Supplementary plan

From: BRYAN BUTCHER <[REDACTED]>
Sent: 14 October 2019 14:53
To: Andrew Wood <[REDACTED]>
Subject: Re: Highways Information - 117, Elmer Road, Elmer - M/42/19

sheet 3 a of 4

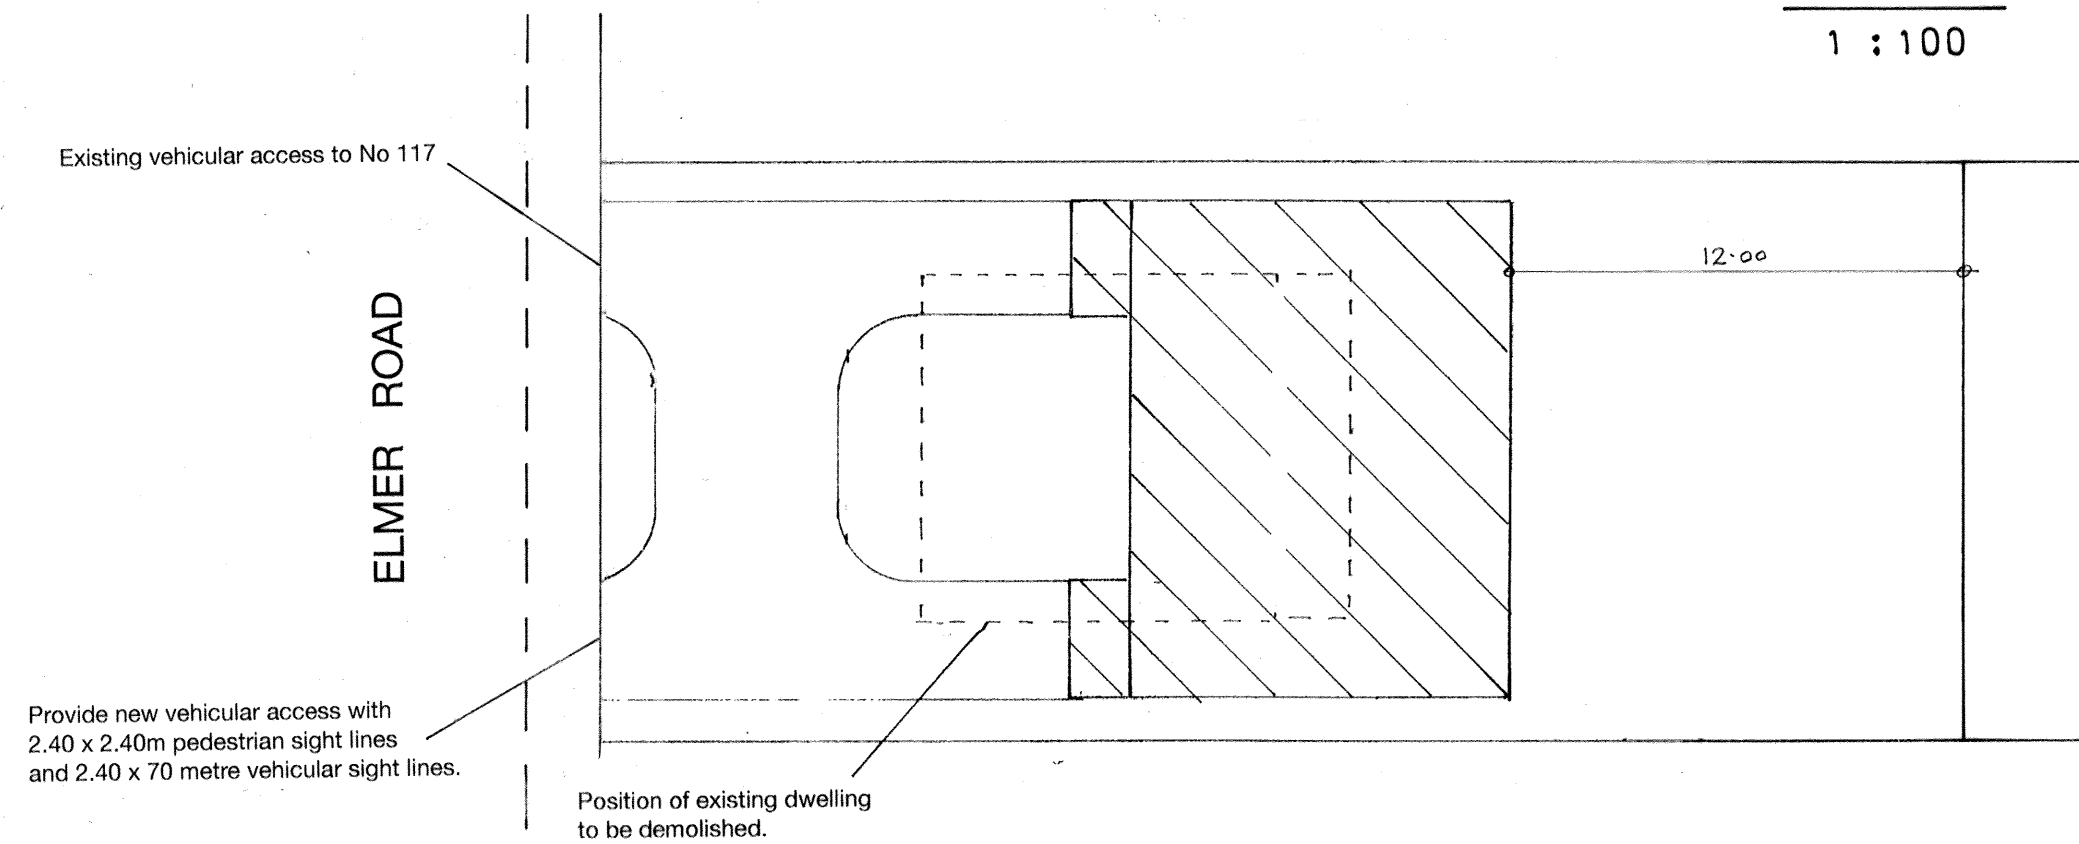
Further to my email below could you please provide the Highways details as requested by West Sussex County Highways (please see attached Highway comments).

Following our telephone conversation I am pleased to attach an amended Parking Layout Plan containing additional detail.
